RIBBLE VALLEY BOROUGH COUNCIL

Officer:	Lee Greenwood	Direct Tel:	01200 414493	Council Offices Church Walk Clitheroe Lancashire BB7 2RA	
Email:	lee.greenwood@ribblevalley.gov.uk				
Our Ref:	RV/2019/ENQ/00062				
Site Location:	26 Church St, Ribchester			Tel: 01200 425111	Fax: 01200 414487
Proposal:	Internal and external alterations including erection of replacement rear extension				
Date:	June 2019

Pre-Application Enquiry Response

NE ELEVATION existing

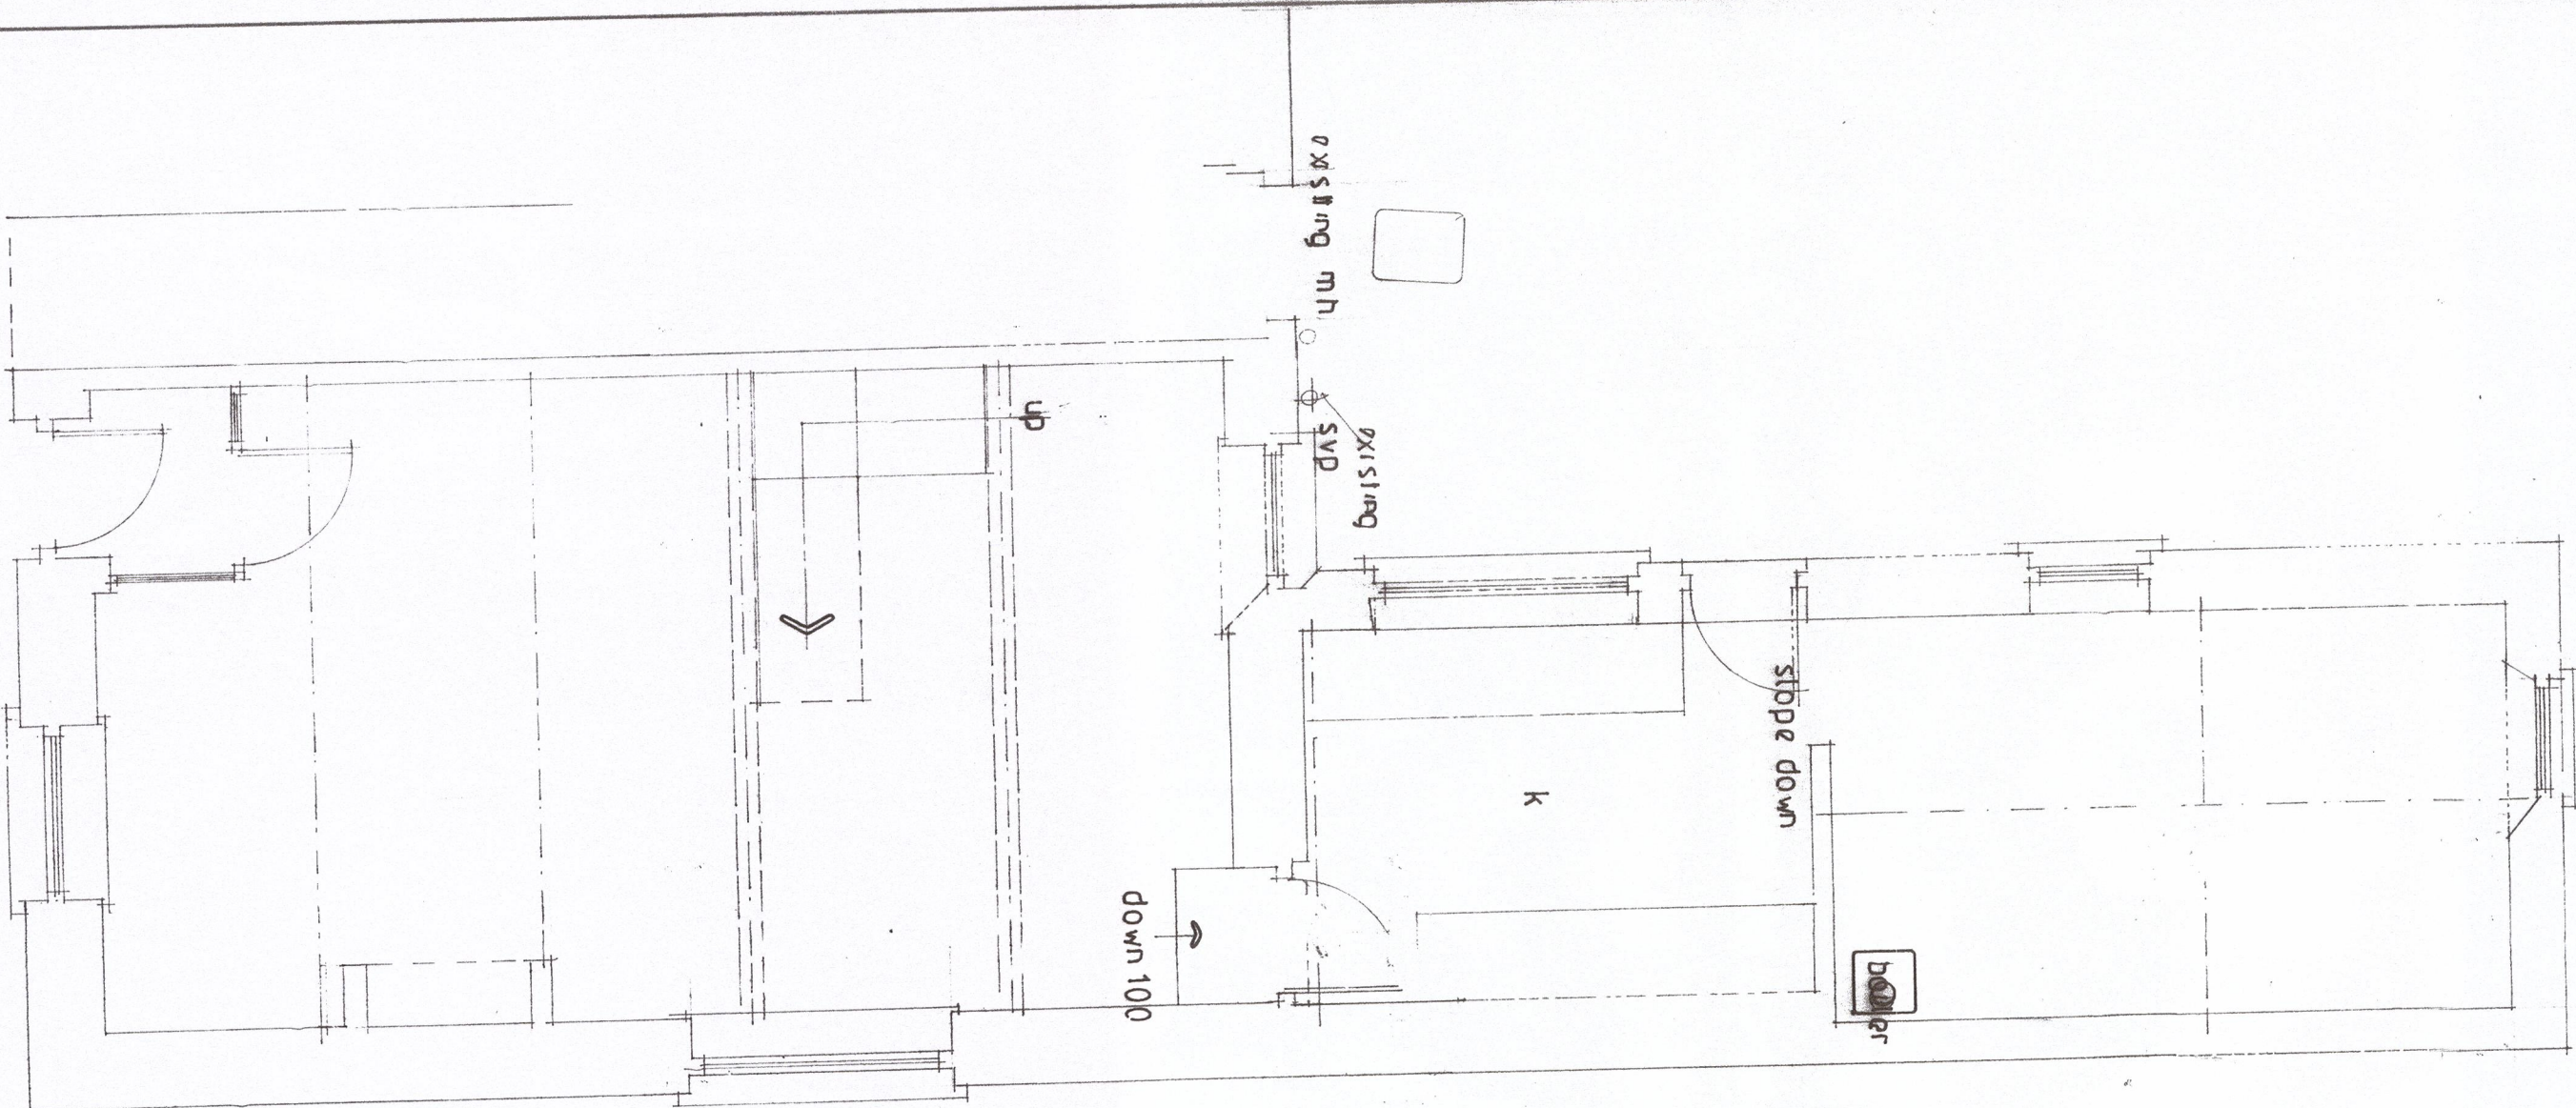
The form and shape of the upper floor rear window opening remains in situ internally, having simply been covered by breeze blocks. This provides the ability to reinstate relatively accurately, with the neighbouring opening as a guide. I would suggest a side hung casement frame.

Therefore providing that the window was not originally blocked for any historically important reason, there would be no objection in principle to these works.

PROPOSED REINSTATEMENT CHIMNEY TO MATCH NUMBER 25 CHURCH STREET scale 1:20

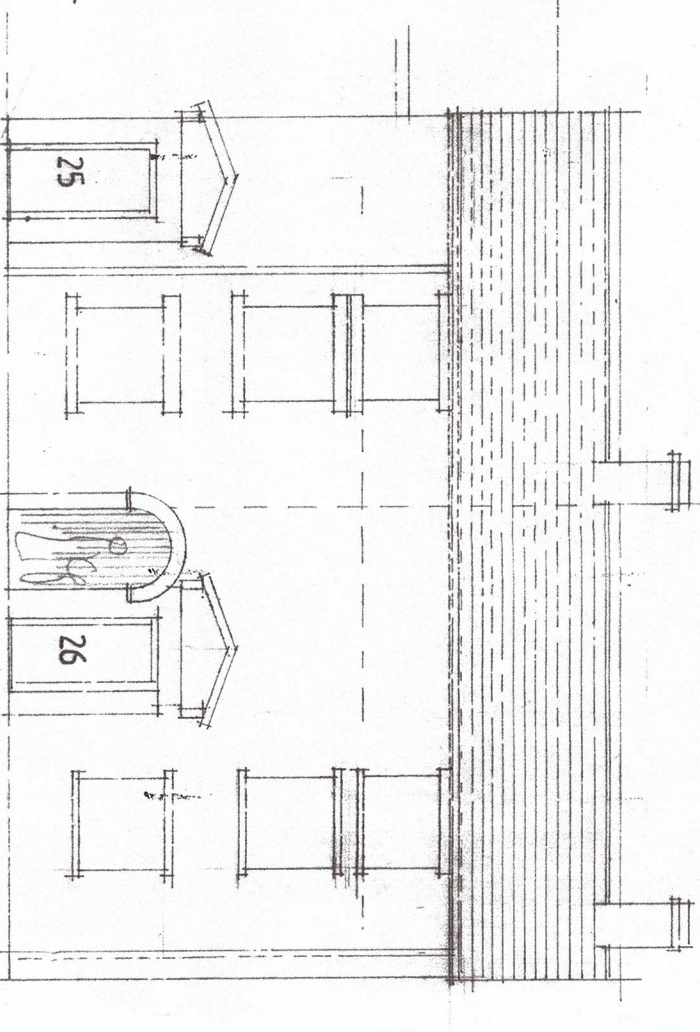
Subject to the accurate reinstatement of the chimney, I do not consider that the proposals would raise undue concerns, accounting for the comments within the Conservation Area Management Guidance.
